CITY OF ALBUQUERQUE

March 17, 2023

**RE: MDS - Montage Subdivision Unit 7 on Bobby Foster
Grading and Drainage Submittal for Preliminary Plat and Grading Permit
Grading Plan Engineer's Stamp Date: 3/5/2023
Drainage Report Engineer's Stamp Date: 3/6/2023
Hydrology File: R16D100A**

Design Review Committee	City Engineer	Last Update	Mo./Day/Yr.	Mo./Day/Yr.
City Project No.	Zone Map No.	Sheet	Of	
775685	R-15-Z, S-15-Z	4	11

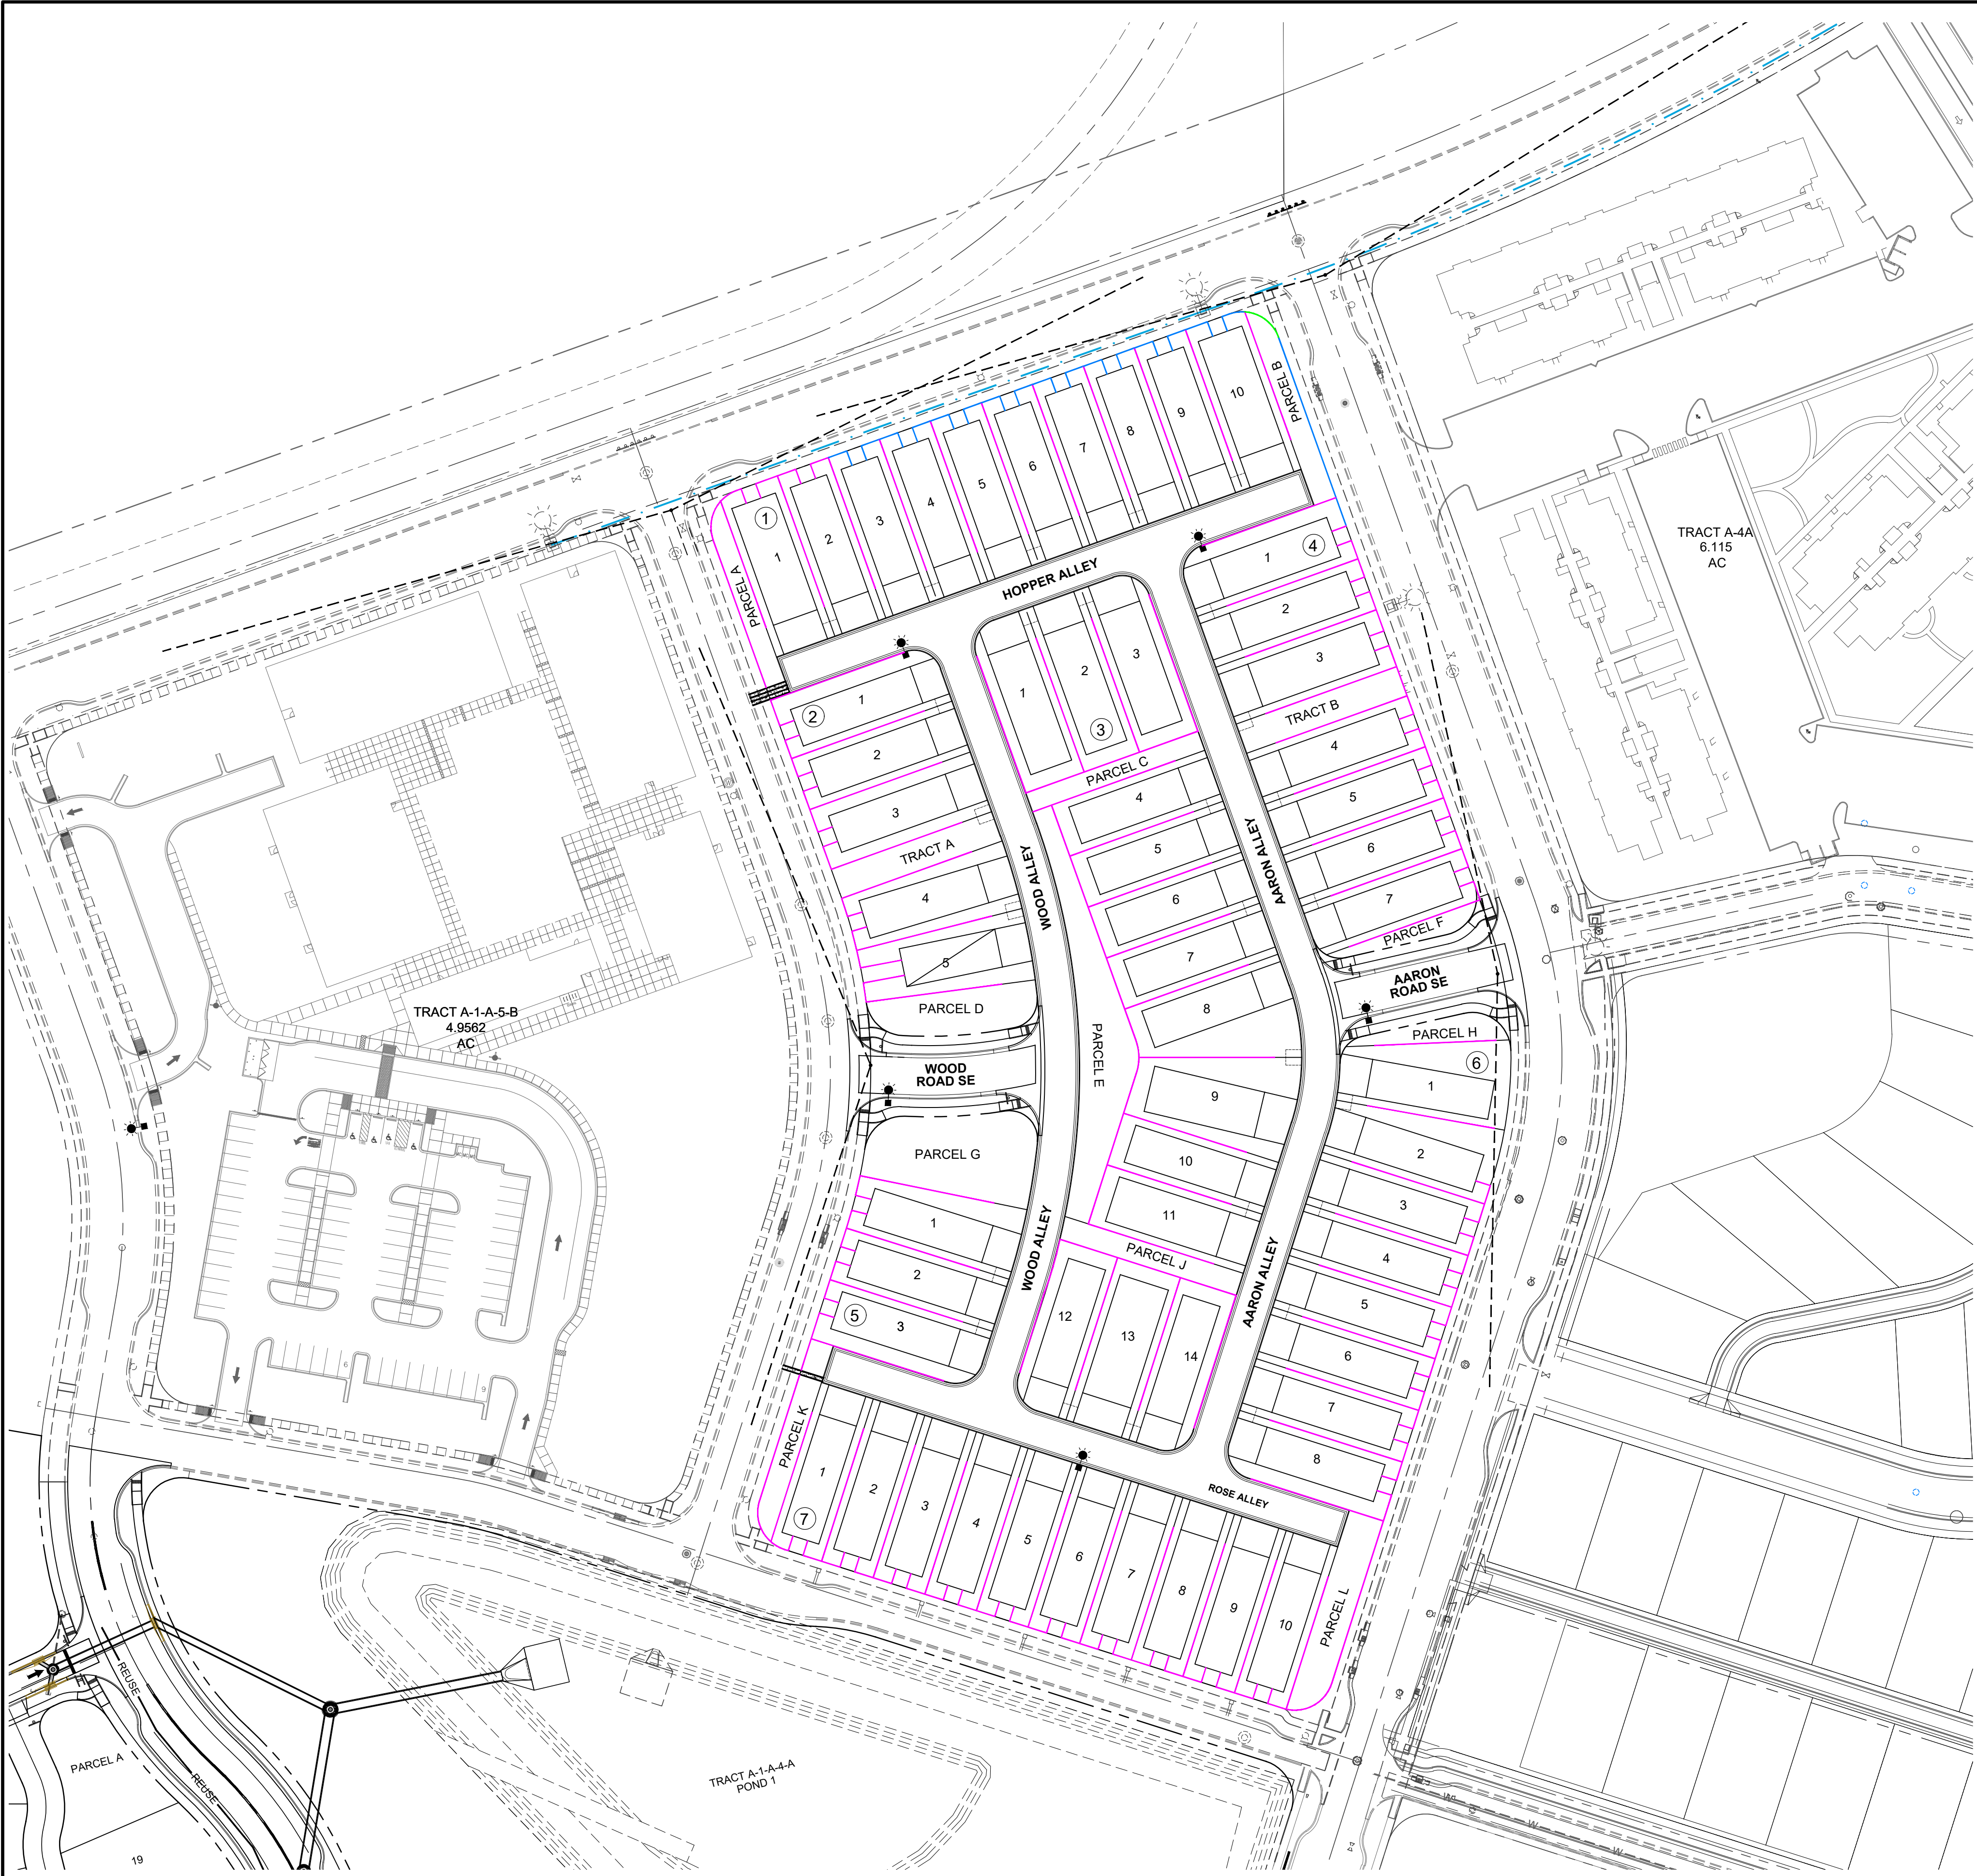
1. Add existing SD and proposed SD on to the legend.
2. Sheet 3, Hopper Alley to Newhall Drive: Add "3-24 inch" to the "Sidewalk Culverts" build note.
3. Sheet 4, Rose Alley to Newhall Drive: Add "1-24 inch" to the "Sidewalk Culvert" build note.
4. Add SO-19 notes. (Attached)
